# KITTITAS COUNTY FIRE MARSHAL'S OFFICE

June 3, 2013

Re: Rinehart (BL-13-00006)

After conducting a review of the above named project, I have the following comments:

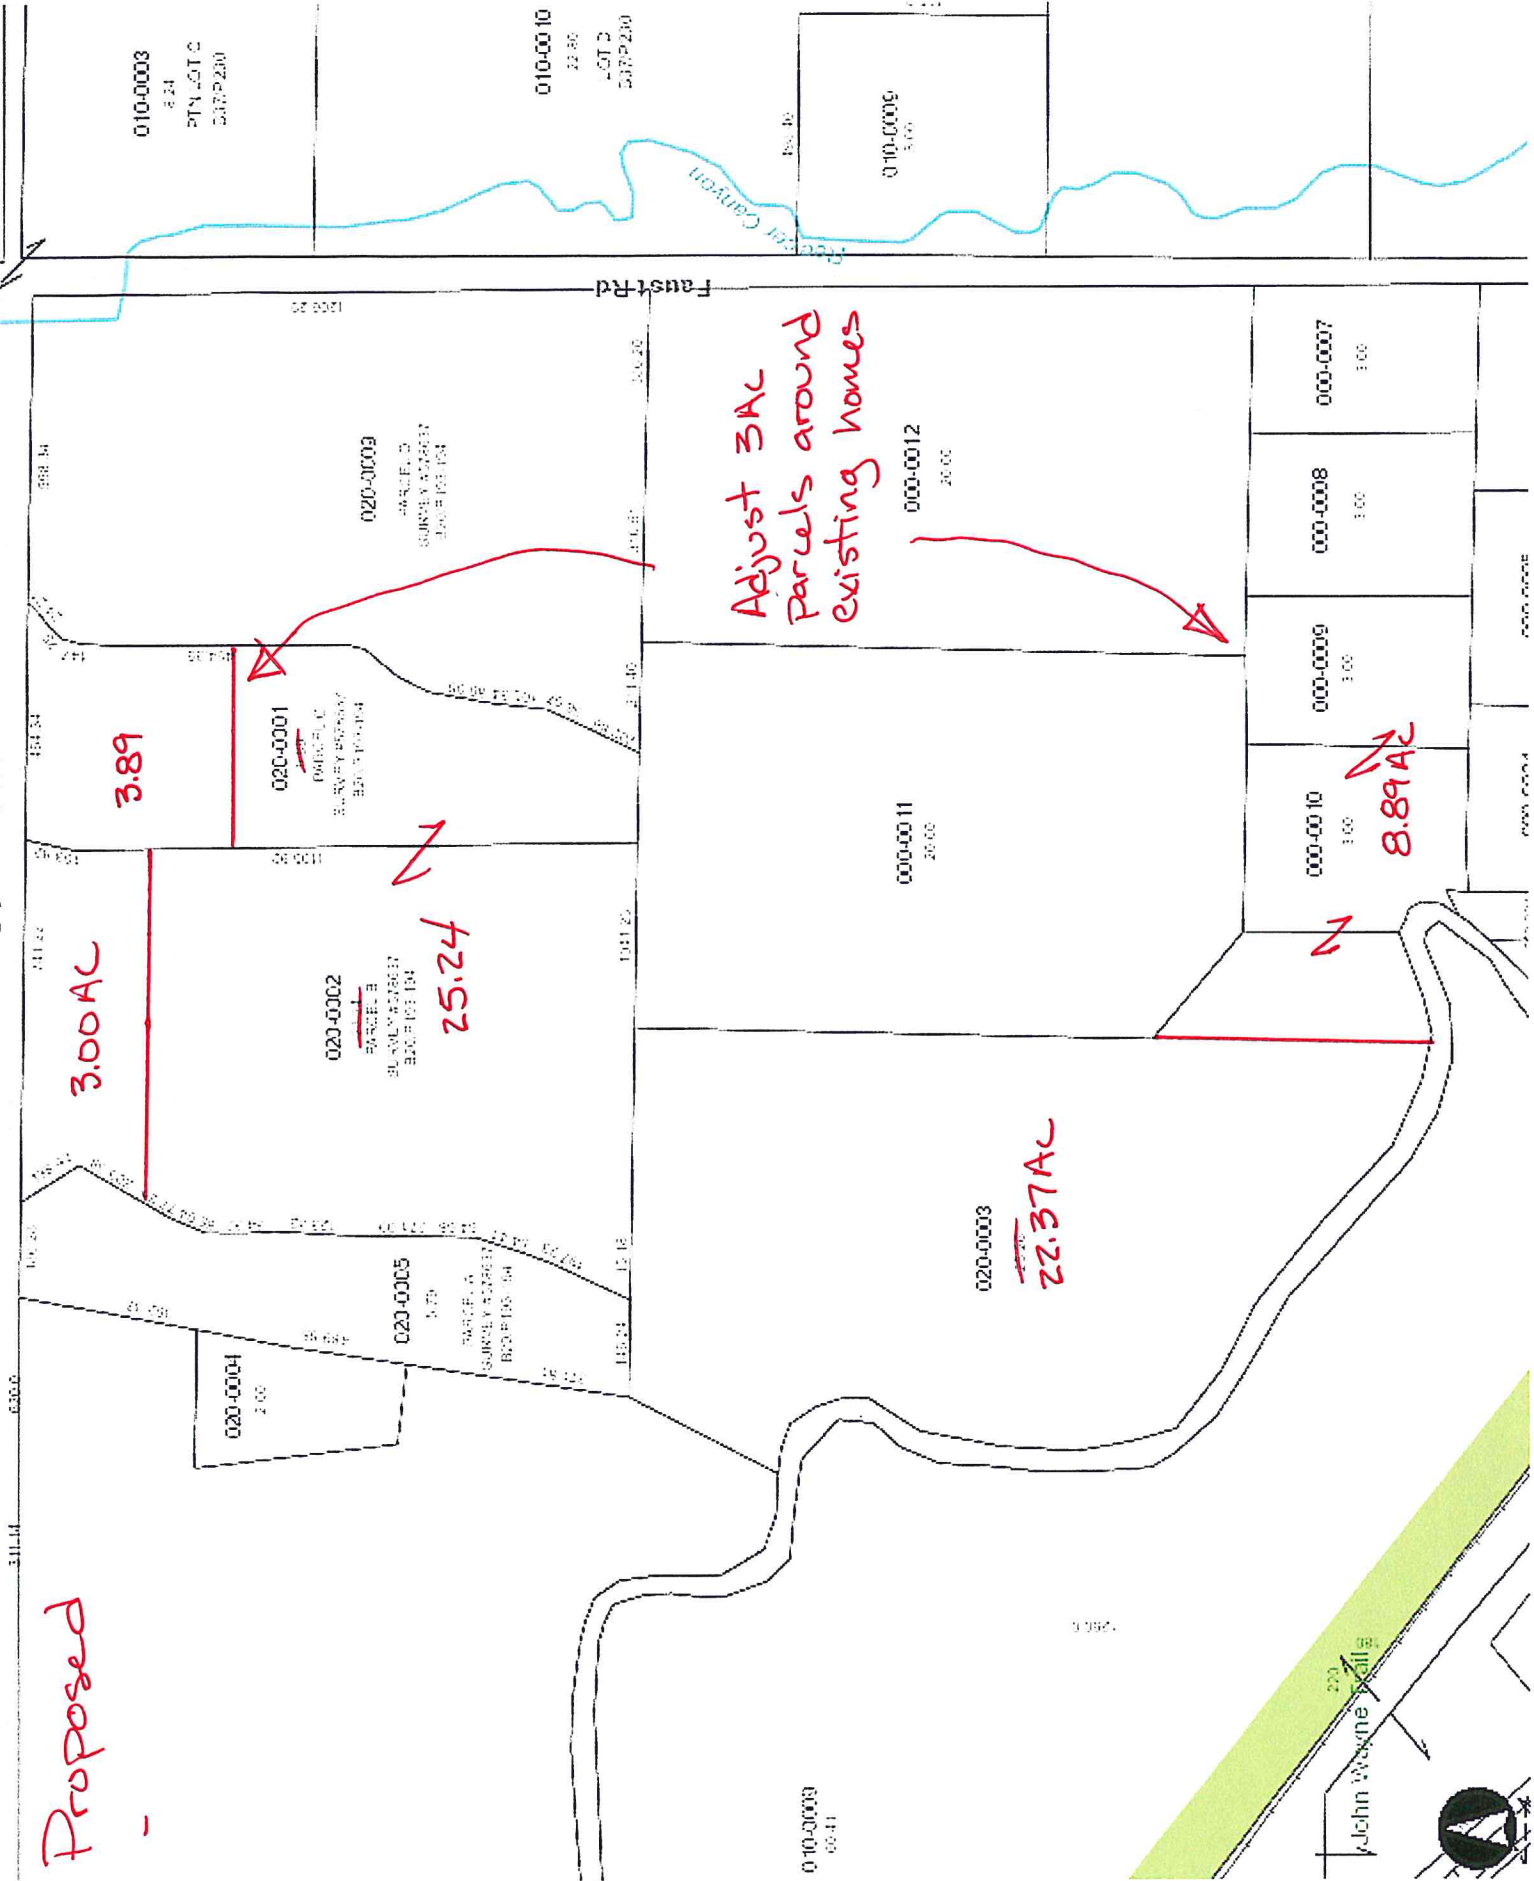
- Ensure that boundary line adjustments do not infringe upon existing structures, to include propane tanks, etc.
- Ensure adequate access for fire apparatus. Any driveways or access points created based off the new lot configurations shall comply with Kittitas County Code 20.02.030.
- All future development must comply with the International Fire Code.
